From: Brian Banister
Sent: 26 August 2008 11:38
To: Planning.Responses
Subject: RE: Planning Consultation on: LU/234/08/

APPLICATION NO: LU/234/08/

Registered: 15-AUG-08
Site Address: 3 River Road Littlehampton

Description of Works: Change of use from Hotel/Hostel to self contained flats (12 in total) studio's, 1 bed and 2 bed apartments & external alterations

PROPOSED NEW DOOR + WINDOW ARRANGEMENT
SCALE 1/100

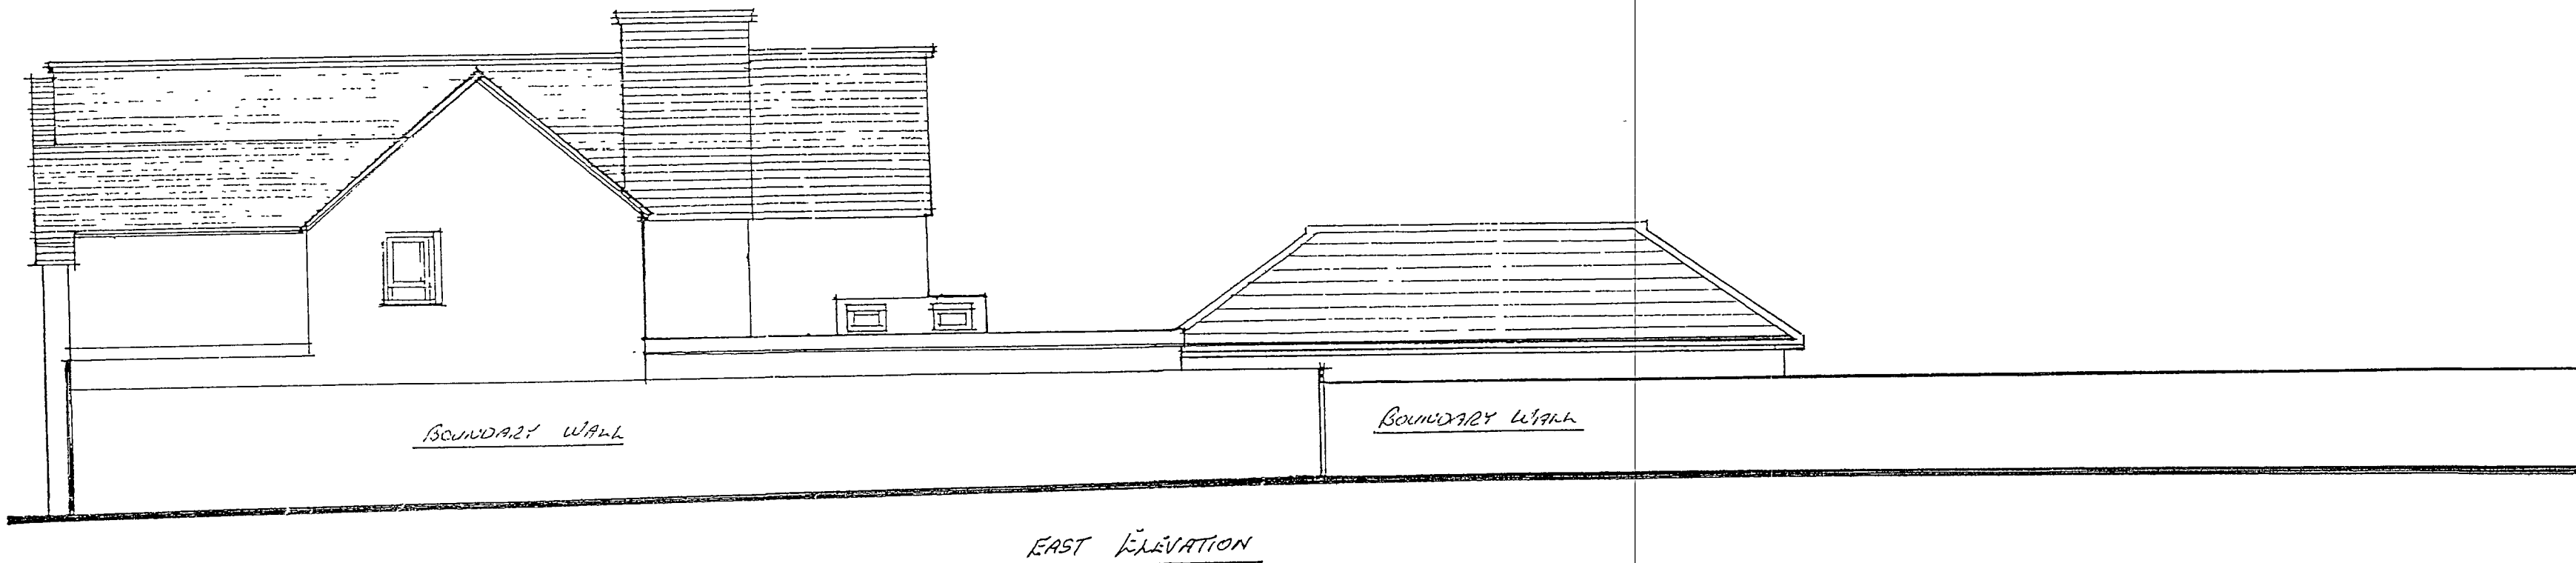
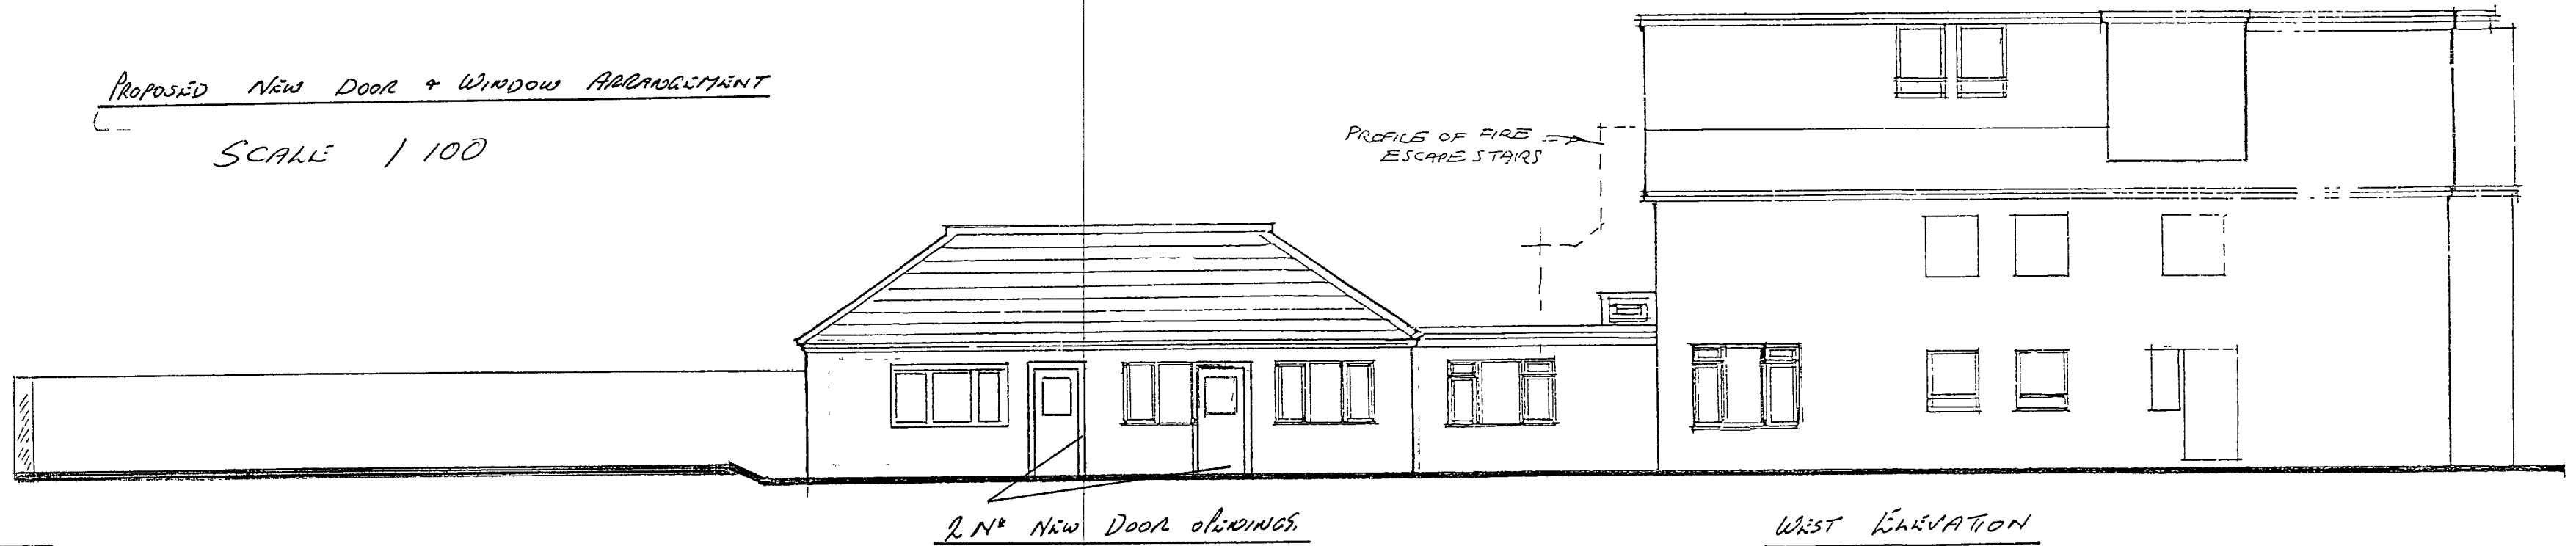
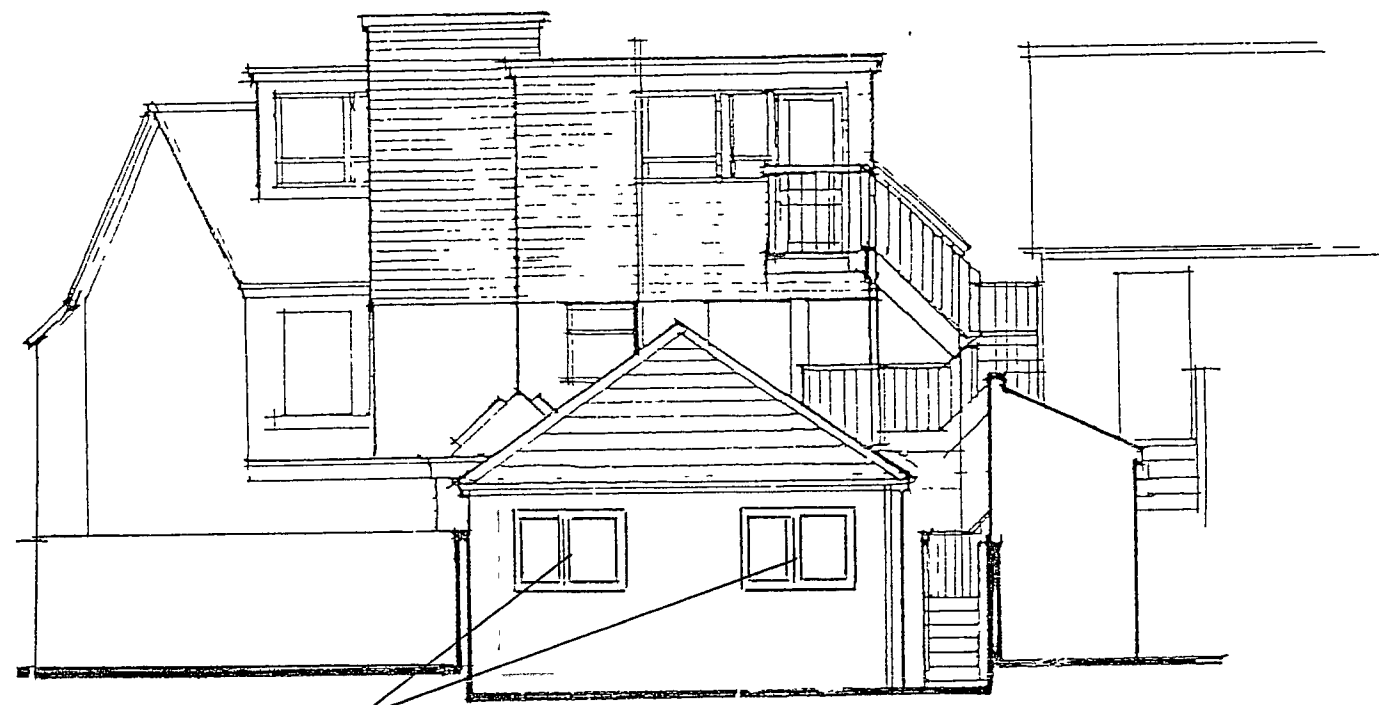
Very minimal elevational changes are proposed and these are at the rear of the building so that I do not consider there will be an adverse effect on the character or appearance of the Conservation Area.
